Ribble Valley Borough Council
Planning Section
Council Offices
Church Walk
Clitheroe
BB7 2RA

Planning Application No: 3/2023/1043

Proposal: Proposed alterations to garage building including removal of first floor bedroom and shower room, external staircase, under-stair storage and wire mesh pen. Extension to provide ground-floor exercise room with shower, toilet and store with upper-level terrace to provide a seating area with access off to a storage area within the garage roof.

Location: 1 Higher Standen Hey Farm Whalley Road Pendleton BB7 1PP

PROPOSED N.E. ELEVATION,
SITE PLAN & LOCATION PLAN.
1 HIGHER STANDEN HEY FARM.
CLITHEROE. LANCs
DRAWING NO. 18/2023/05.

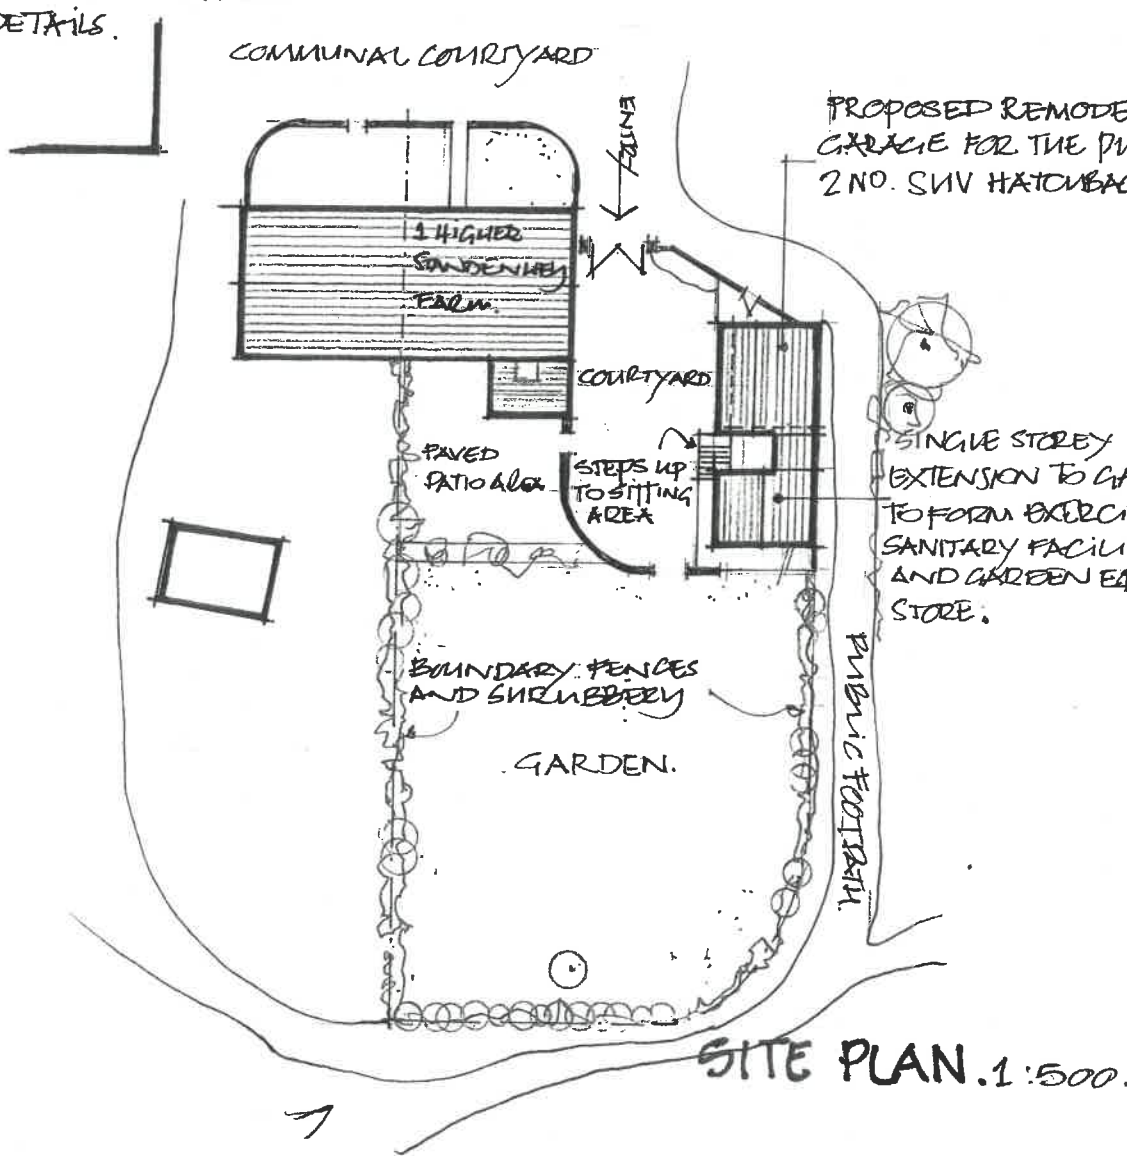
Public right of way FP0332009 should not be obstructed during construction works.
